Your ref: SSD 23330227  
File no: MC-21-00004

**SSD 23330227 – Upgrades to John Palmer Public School - 85 The Ponds Boulevard, The Ponds**

# Blacktown Council's submission to SSD 23330227 – Upgrades to John Palmer Public School

Figure 1 Community use of school facilities at JPPS (Figure 44 of the EIS)
Source: PTW Architects

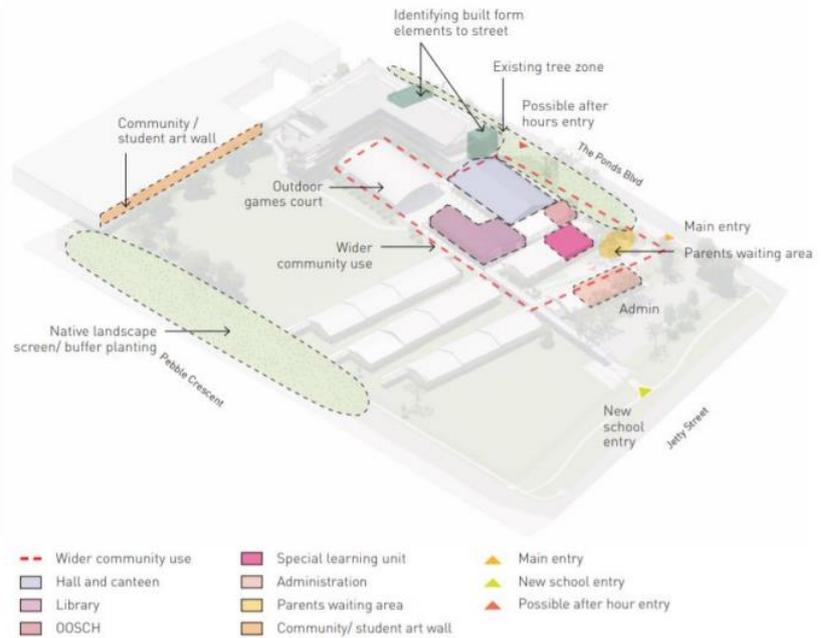
- a. The Environmental Impact Statement on page 53 notes that there are no proposed changes to community use of the school facilities. There are opportunities to increase community use and access to the school facilities as outlined in the Schools Infrastructure NSW Share our Space program.
- Is John Palmer Public School currently on the list for the Share our Space program? If not, why not?
  - The upgrade for the school must not present a barrier to John Palmer Public School being considered and included in the Share our Space list for the future.
- b. Figure 44 of page 53 shows the area of the school dedicated to wider community use. Is there any reason that the sports field has not been included? There are potential activation opportunities that can take place through the Share our Space program on the field as well as the sports court.

Figure 7 Detailed landscape plan showing changes to fencing at the north-east boundary of the site

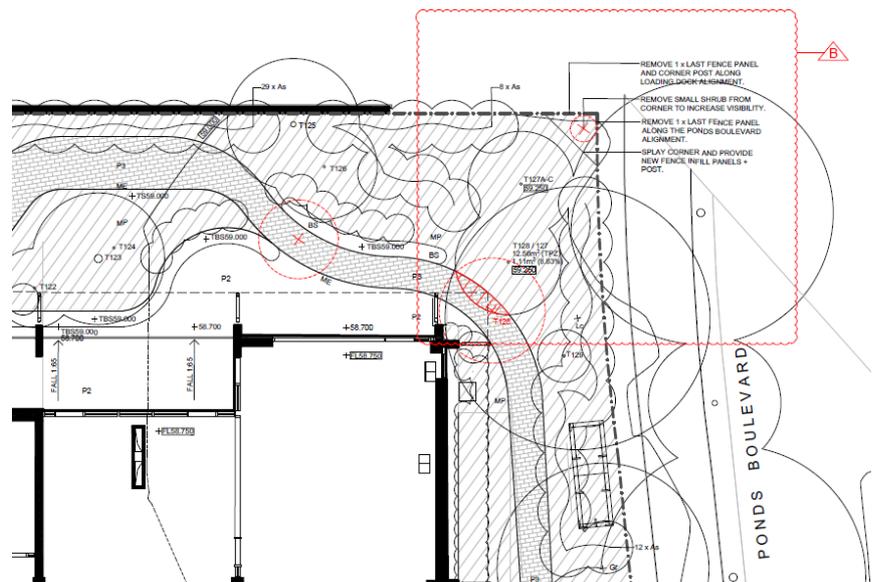
- b. **Splay:** A pedestrian safety issue has been identified due to not having splay at the north-east boundary of the school with The Ponds Shopping Centre vehicular access along The Ponds Boulevard. It is necessary that a splay be provided by removing a few panels of the fence and landscaping to improve the line of sight for pedestrians at The Ponds Shopping Centre vehicular access. This will need to be reflected on an amended plan.
